22.04.20

RE: STATE SIGNIFICANT DEVELOPMENT SSD 7874

Figure 3.1.4 Proposed envelope - elevation (FJMT).

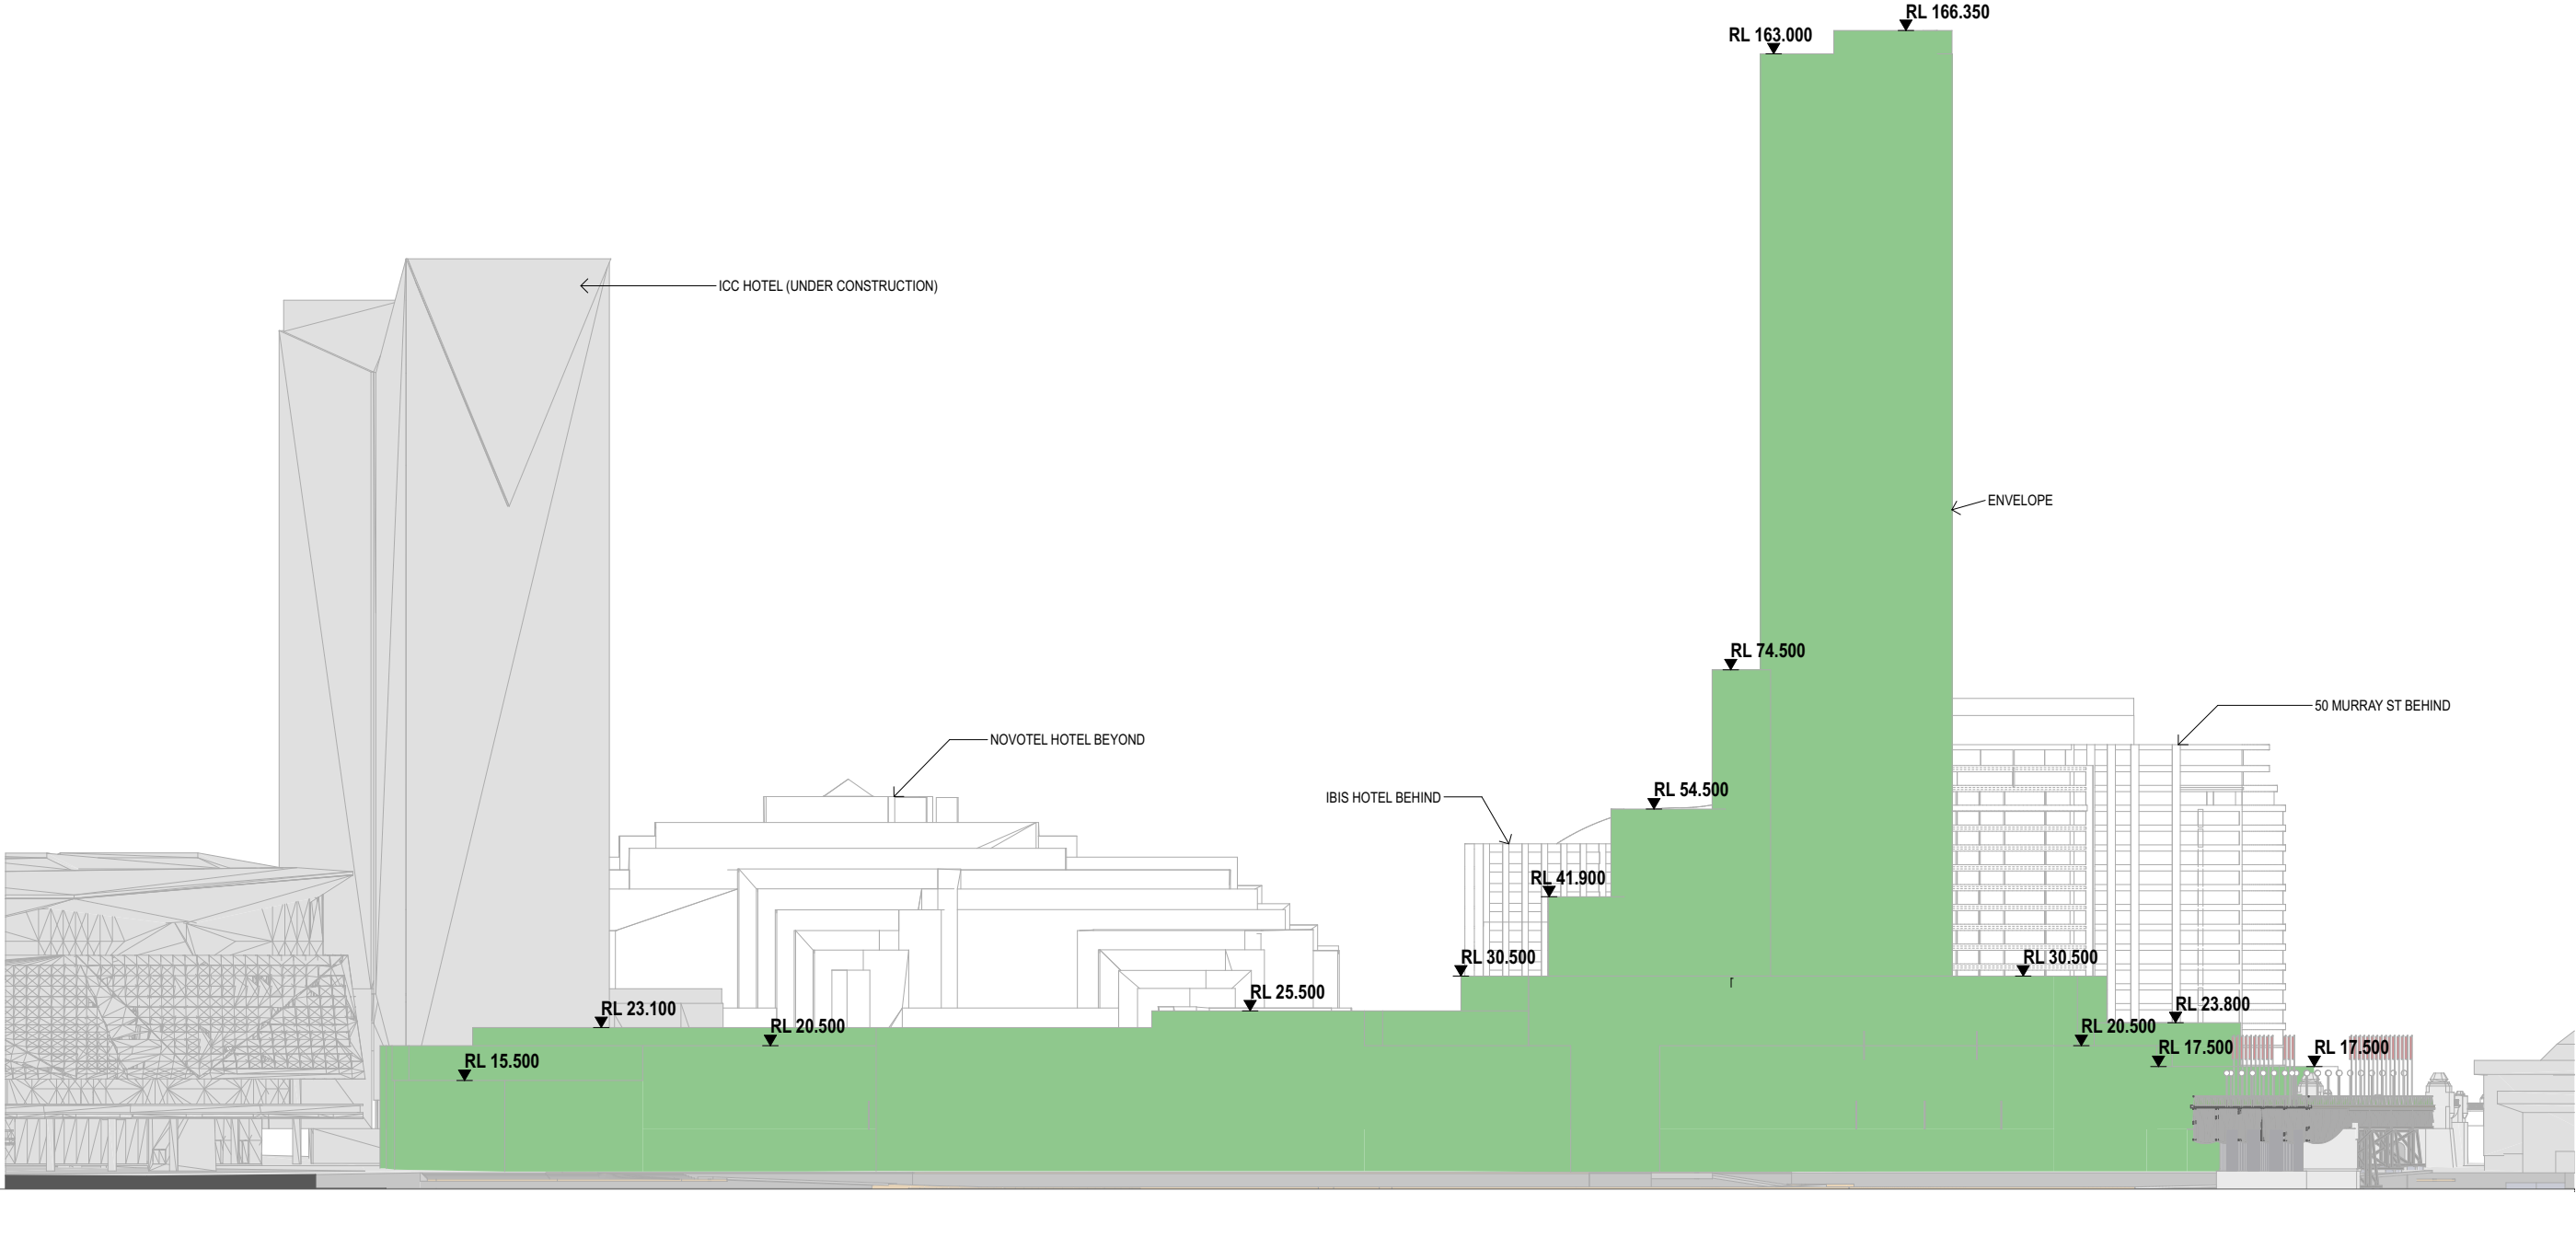
Any extreme increase in height at the northern end of the site will not only create an adhoc/piecemeal approach to town planning in NSW, but will also obliterate iconic views from neighbouring residential properties.

The current RL for the Harbourside envelope is 19M. This really should only be 12M in front of the western buttress to ensure uniformity and maintain the proud significance of the Heritage listed bridge. Further to this, any increase in the height of the envelope at the northern end with obliterate iconic views of both the precinct and the bridge itself. Given the extremely large footprint of the envelope, it is unnecessary for the increase on height at this northern area of the site. There is sufficient opportunity elsewhere to develop appropriate space.

There is an opportunity for any significant envelope changes to form a satisfactory relationship with the surrounding properties. At present, the proposed height of 25M at the north of the site, does not allow for this. It will obliterate iconic views at the north of the site and diminish solar access.

Figure 4.5.5 Pymont Bridge setbacks proposed

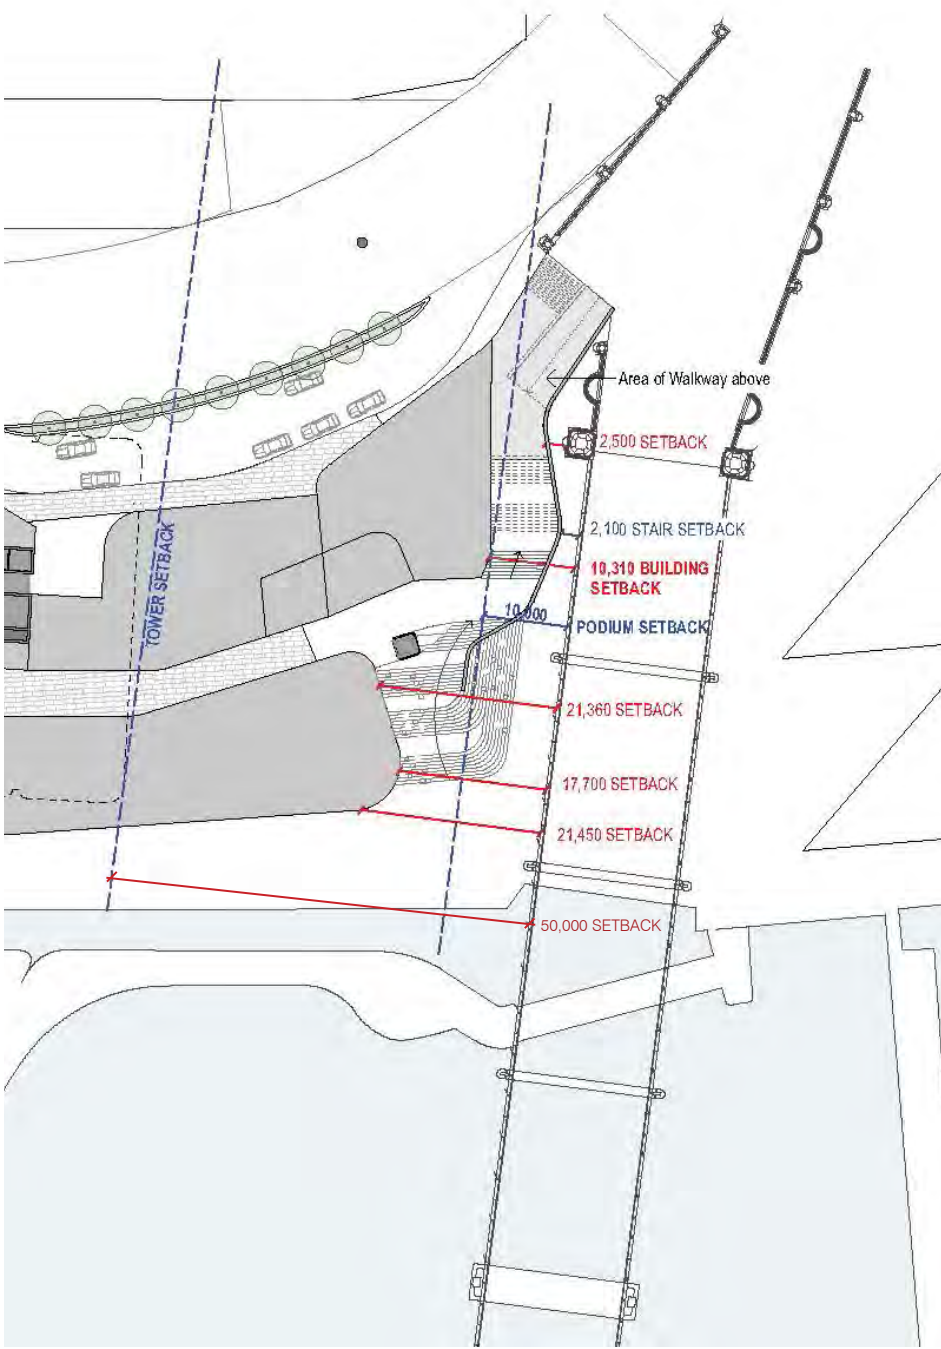
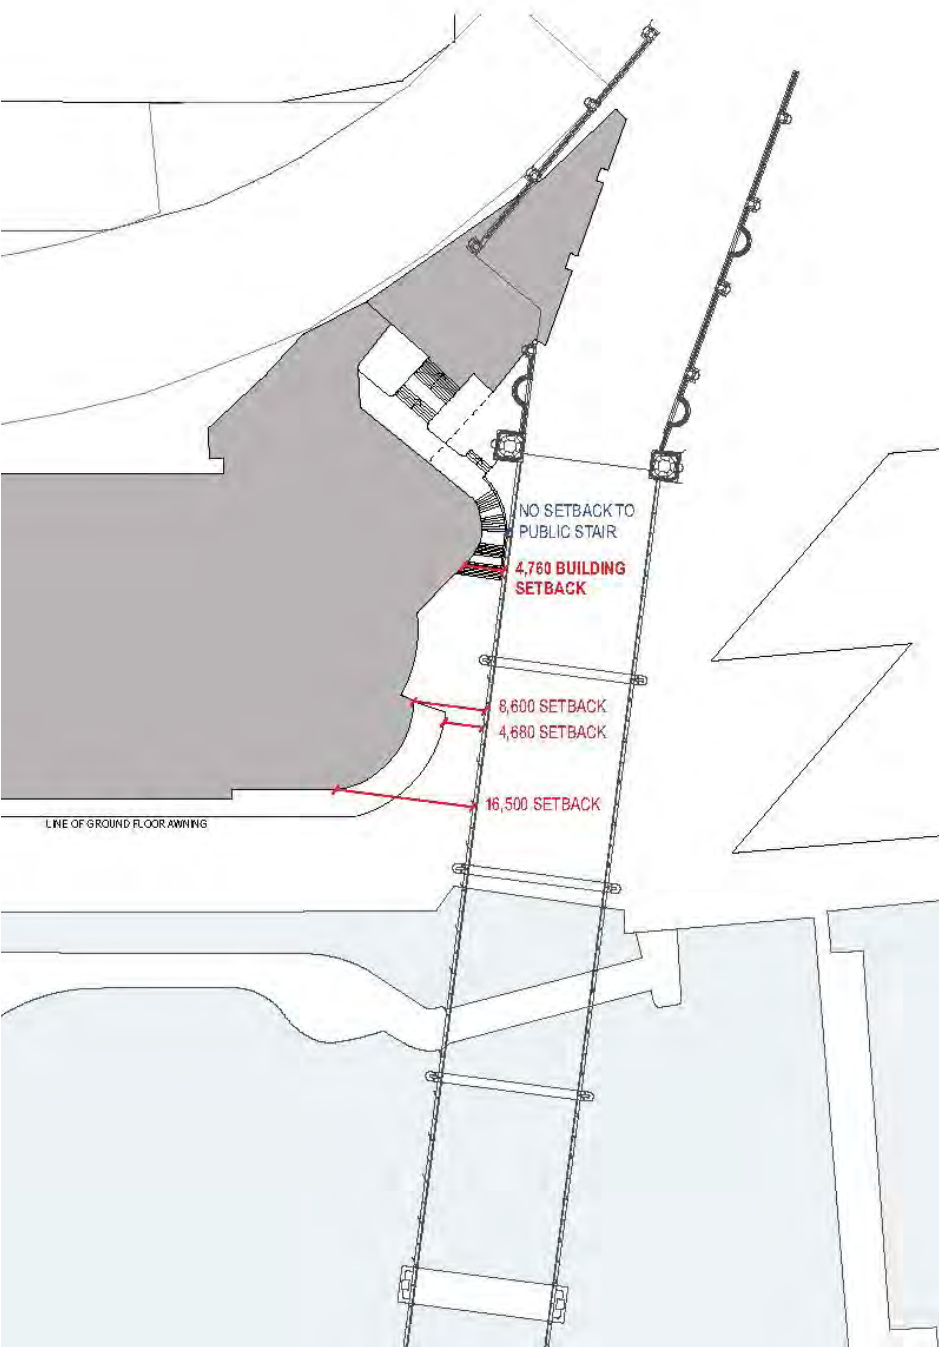
There is currently an opportunity to correct the issues associated with an unsatisfactory relationship with the bridge and approach.

Below is a site survey obtained from the current application. As evidenced, the western buttress is located 'behind' or to the west of the envelope. As such, the principles applied to the Cockle bay approval should be applied in this application also.

The City of Sydney stated that the proposal “obliterates the heritage significance of the Pyrmont Bridge”, these statements are of immense concern to the people of Sydney. If the setbacks are maintained in line with the Cockle bay approval, this will clearly evidence a succinct plan to development in the area.
